RE: PICTON HIGH SCHOOL RESPONSE TO SUBMISSIONS – RMS COMMENTS

We write with regard to Picton High School Redevelopment (SSD 17_8640), specifically in response to your email dated 12 December 2018 requesting responses to comments raised by RMS following the lodgement of the Response to Submissions package (dated 30 October 2018).

RE: PICTON HIGH SCHOOL RESPONSE TO SUBMISSIONS

Picton High School
Swept Path Assessment
14.5m Bus Entry - Right Turn

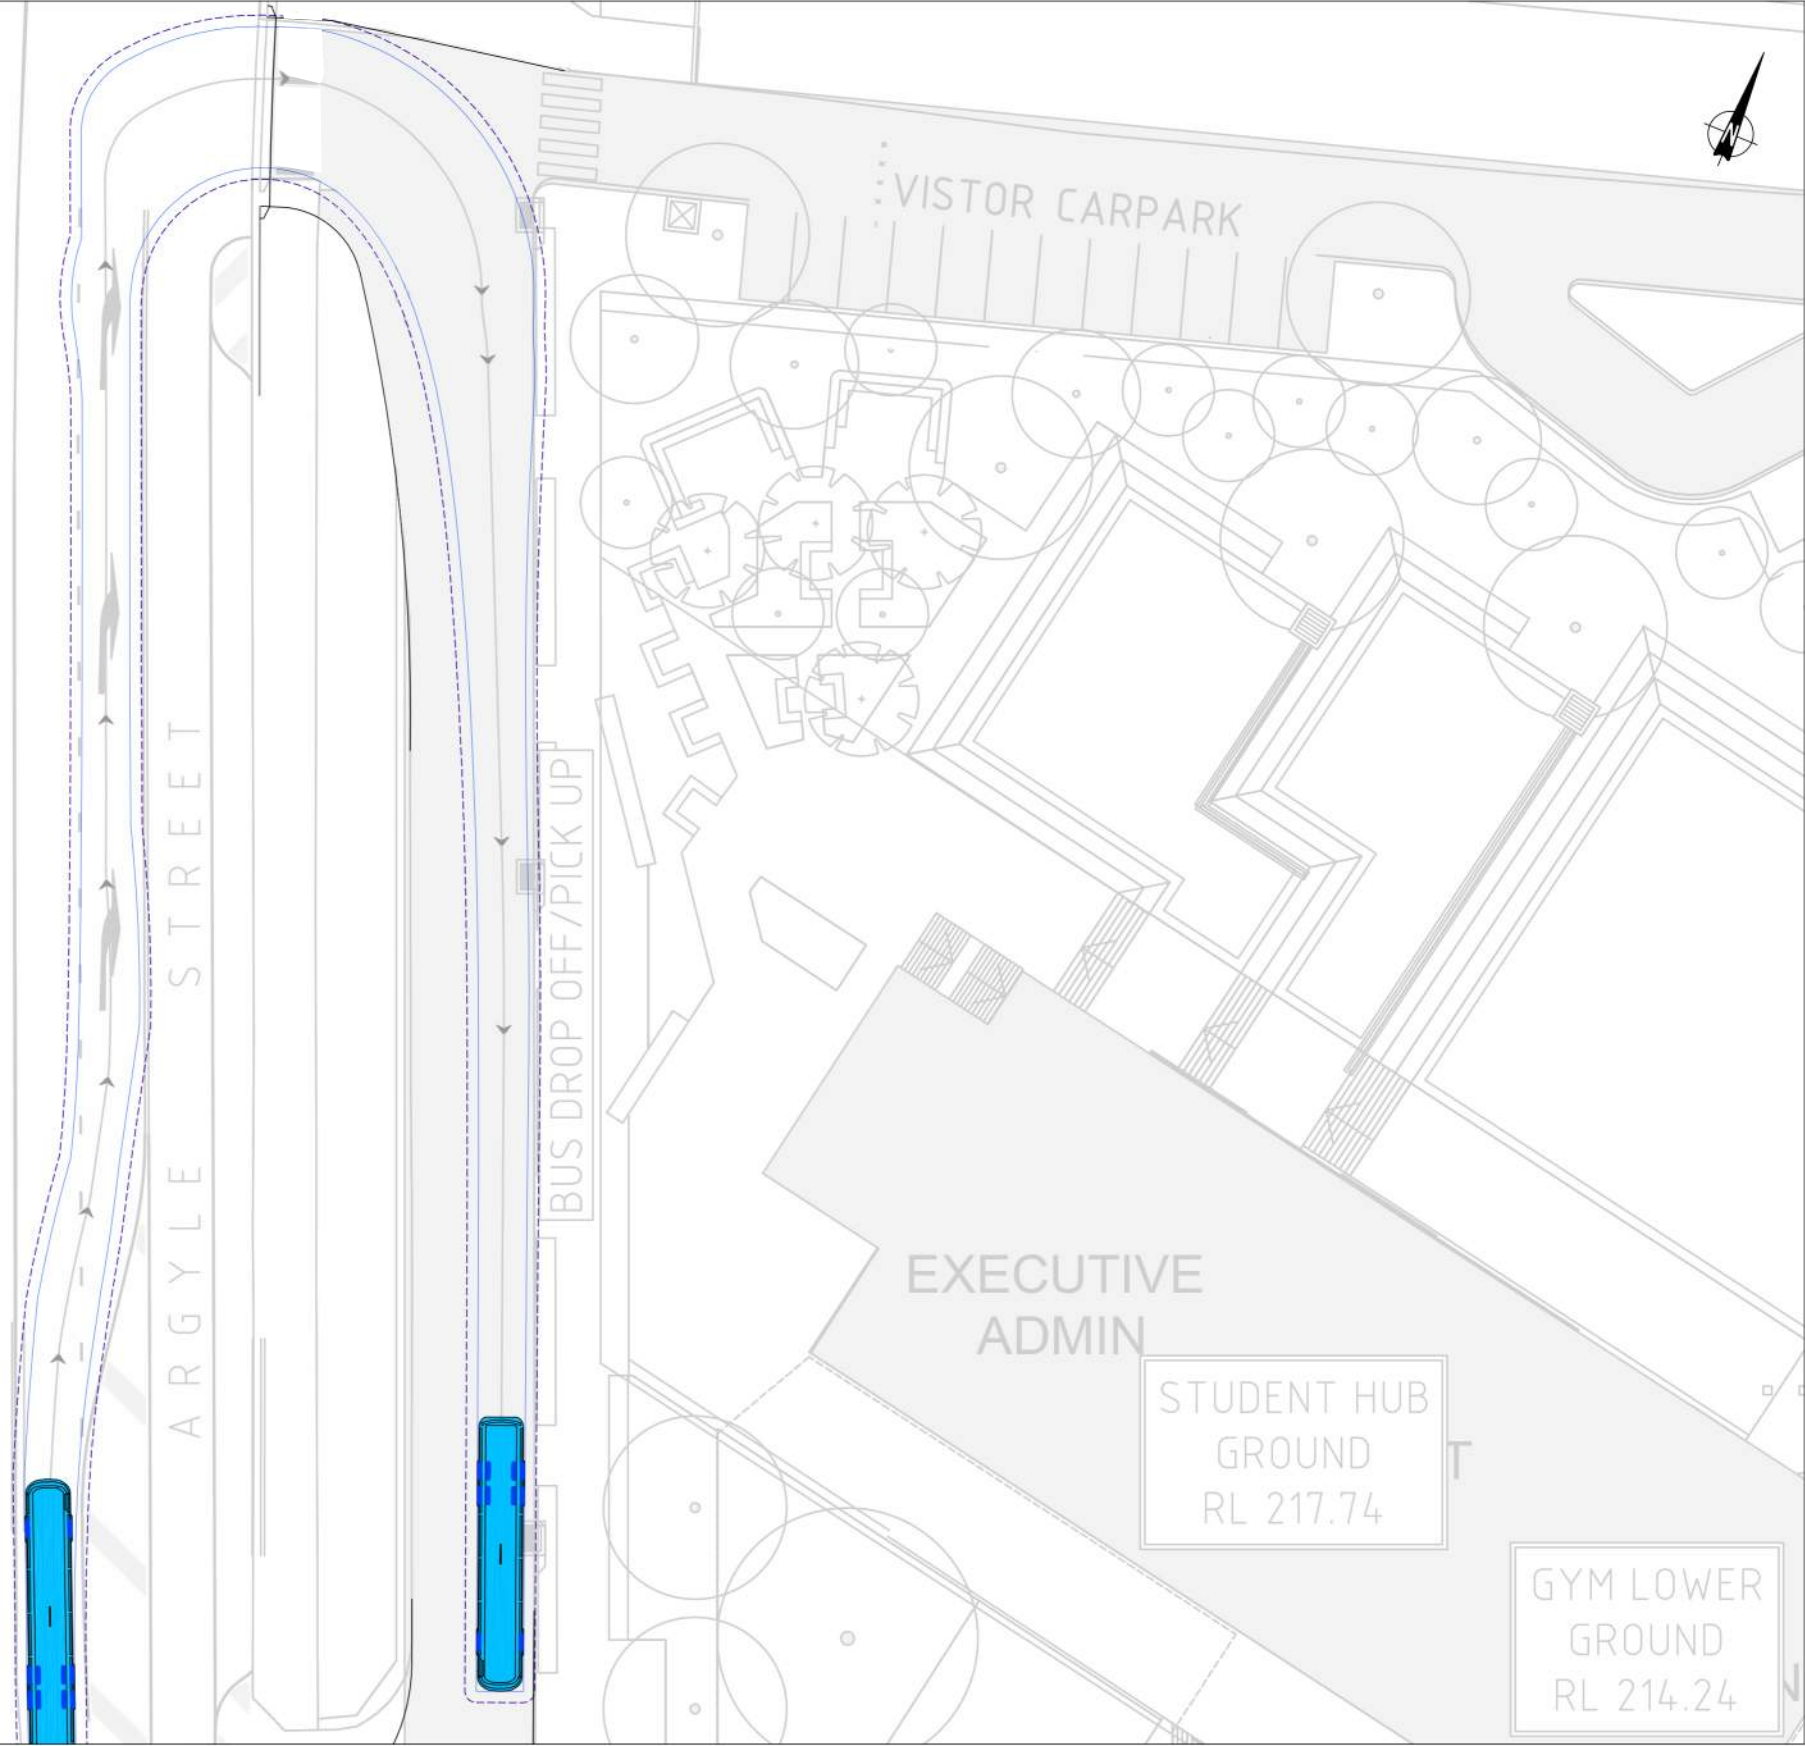
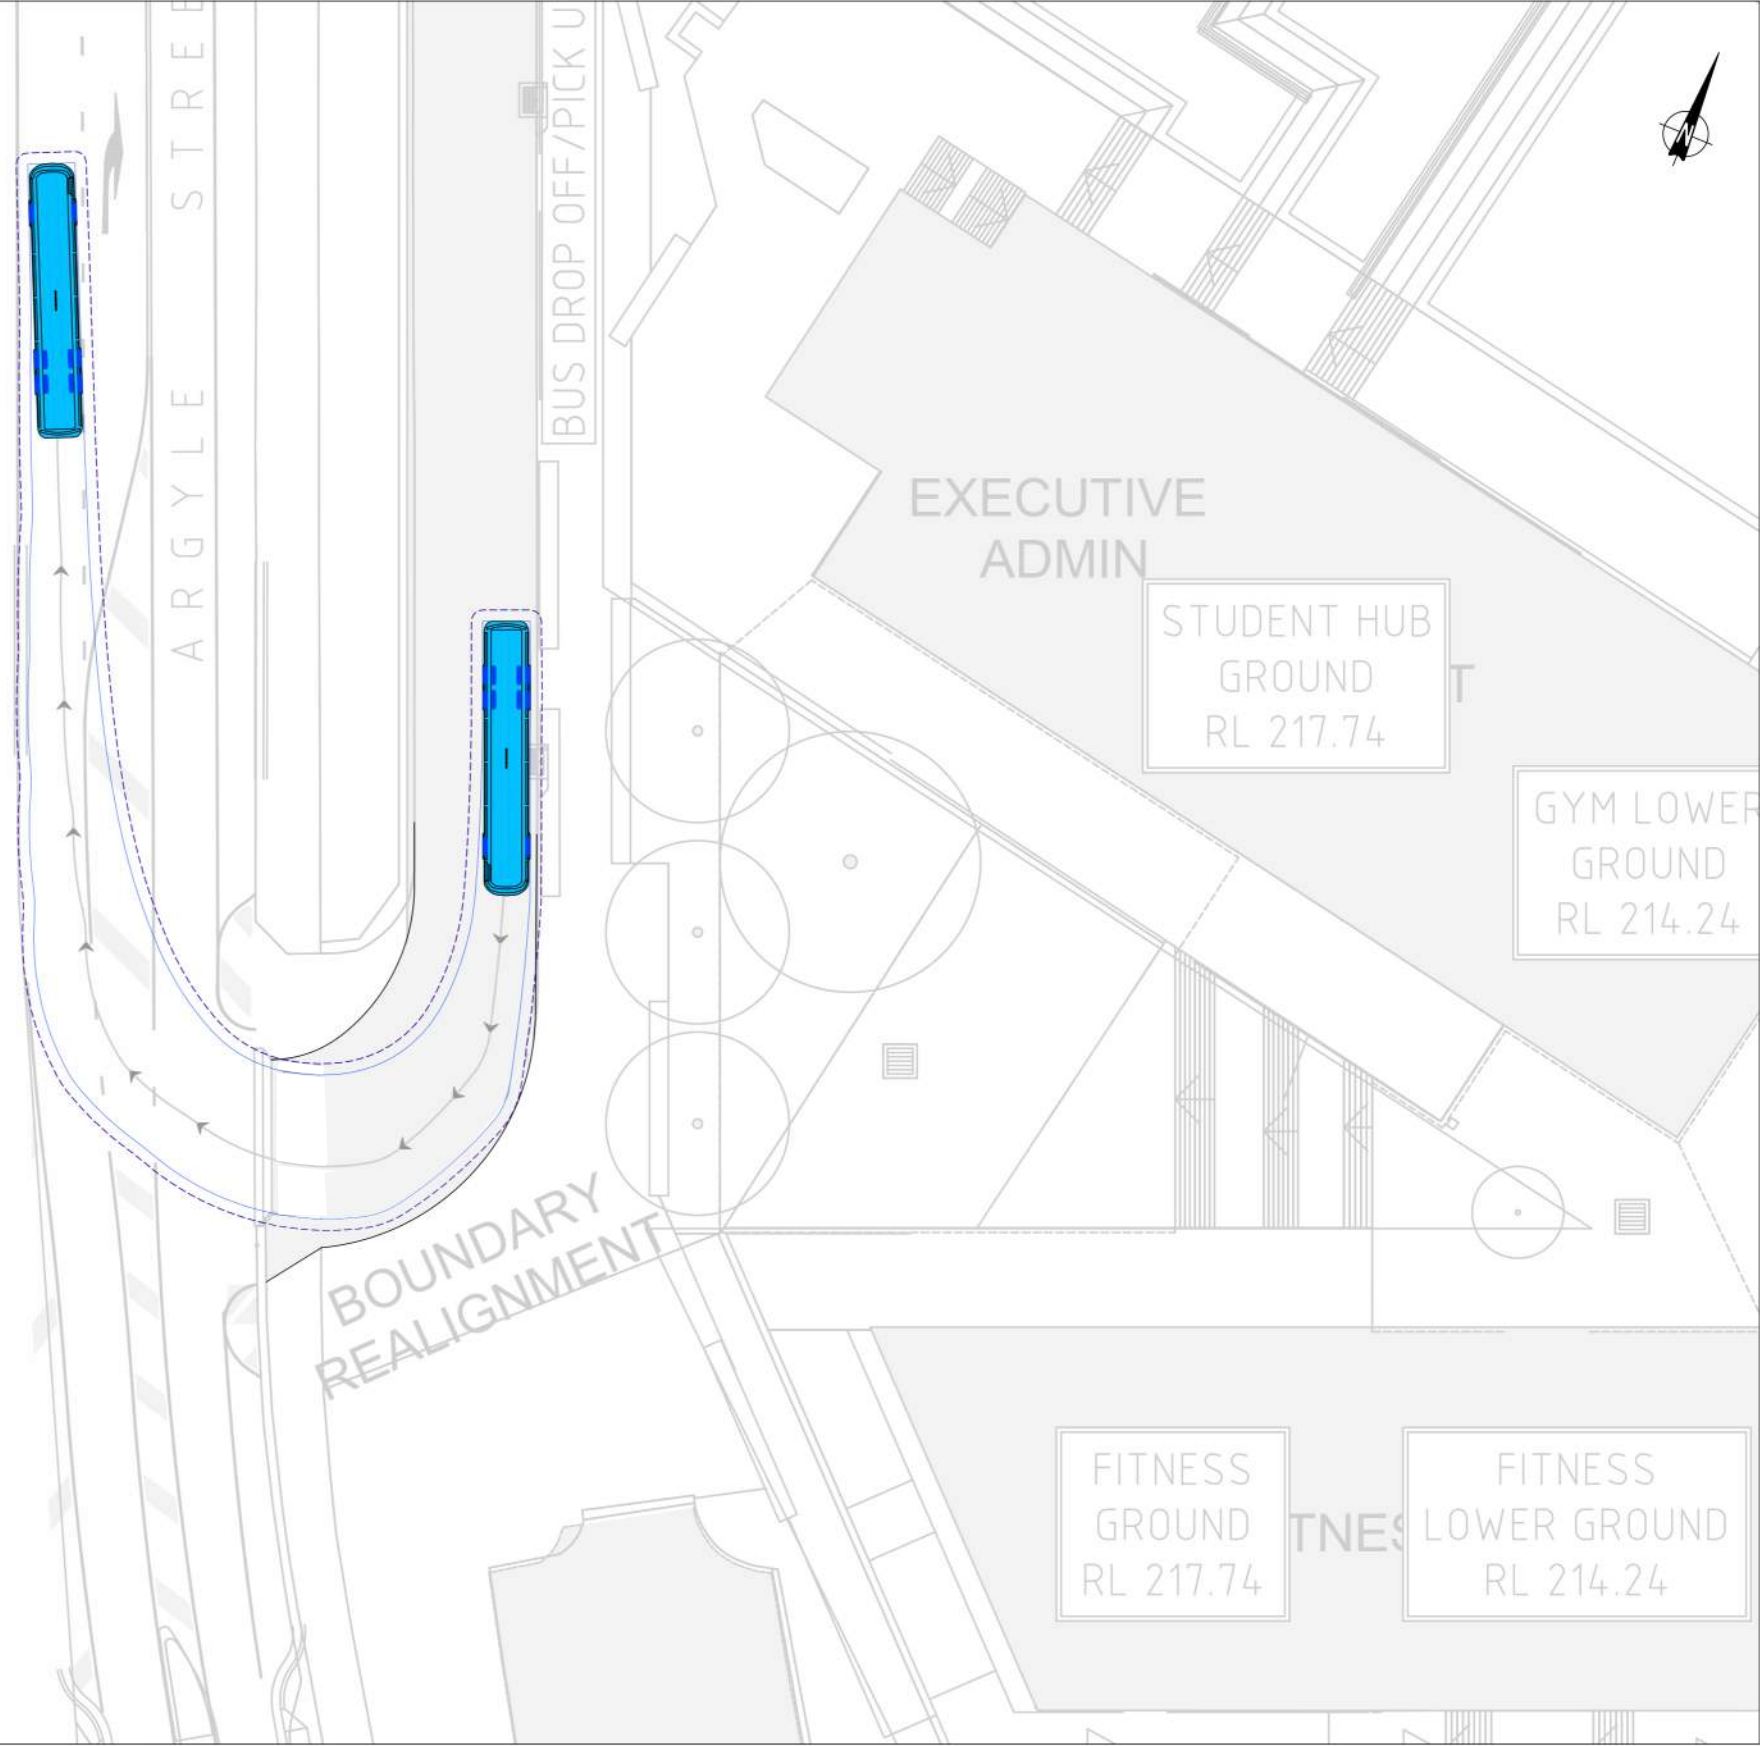
<p>Swept Path Assessment</p> <p>RMS notes that the updated <i>Traffic and Accessibility Impact Assessment</i> (prepared by TDG, Ref: 14584 ta 180803 final, dated 3 August 2018) contains updated turning manoeuvres for buses entering and leaving the site. As detailed in RMS' previous advice the plans provided should comply with Austroads requirements (e.g. speeds used, required clearances, etc). The following comments are provided on the updated plans:</p> <ul style="list-style-type: none"> • The turning path for the bus entering the bus parking area fronting Argyle Street from the north does not appear to have been applied correctly. The radii used are too tight with the vehicle turning at too low a speed. If applied correctly the bus would not be able to park in the last parking space without reversing and manoeuvring into the position; • The bus turning from the right turn bay cannot enter the parking area without the front overhang crossing onto the footpath; • The turning path for the bus exiting the bus parking area to the north has not been applied correctly. The radii used are too tight with the vehicle turning at too low a speed; 	<p>As shown in Attachment B (swept path analysis at 5km/h) this will be the maximum design bus that will be used on-site. The bus access arrangement has been revised to avoid the front overhang.</p> <p>The bus vehicle turning path has been designed in accordance with the 'Austroads 2013 – Design Vehicles and Turning Path Templates Guide'.</p> <p>As specified in the Austroads Guide, the long rigid bus of 14.5 metres long, is designed to a speed of 5km/h.</p> <p>In addition, we have also prepared the bus movement at a design speed of 10km/h (refer to Attachment C).</p> <p>The bus operations (loading and unloading of students) will be managed by staff to ensure students get on the correct bus service, and fill up the first bus before proceeding with the second bus.</p>

Issue	Response
<ul style="list-style-type: none"> When the turning paths are applied correctly a bus is unable to enter the bus parking area if another bus is occupying the end parking space. This could cause queuing onto Argyle Street; If the number of buses shown within the Argyle Street bus pick up/drop off area are to be contained within this area then they would have to exit in the same order as they arrive (i.e. no space between the buses to allow them to manoeuvre into or out of their space if other buses are occupying the adjacent spaces). This has the potential to cause congestion which will impact upon the operation of Argyle Street; <p>Noting the comments above RMS believes that the applicant should be requested to provide the above detail to council for review and comment prior to the determination of SSD 8640.</p>	
School Zones	
<p>RMS notes that the RTS covering letter prepared by Ethos Urban (dated 30 October 2018) details, in part, that the determination of the school zones required (i.e. new school zone and/or amendments to the existing school zone) will be addressed following approval of the current SSD application. While this is correct, it has now become apparent that a temporary school is being established on the site with access to be gained from Wonga Road. The details of the temporary school were not discussed in any detail in the information that has been provided to date. While RMS acknowledges that the temporary school does not form part of the current SSD application, if it is intended to occupy the temporary school at the start of the 2019 school year RMS advises that the new school zone for Wonga Road and associated speed zone reductions will need to be in place before the commencement of use of the temporary school. The new school zone in Wonga Road to be determined in consultation with RMS's Road User Safety Project Officer. It is therefore requested that DPE inform the applicant that they should make contact with Amanda Priestley at RMS on 4221 2517 to further progress the new school zone that will be required in Wonga Road to service the proposed temporary school.</p>	<p>Stephen Craig from Taylor Construction has contacted Amanda Priestley regarding the School Zones on Wonga Road (refer to Attachment D). A concept School Zone plan has been prepared (refer to Attachment E).</p>
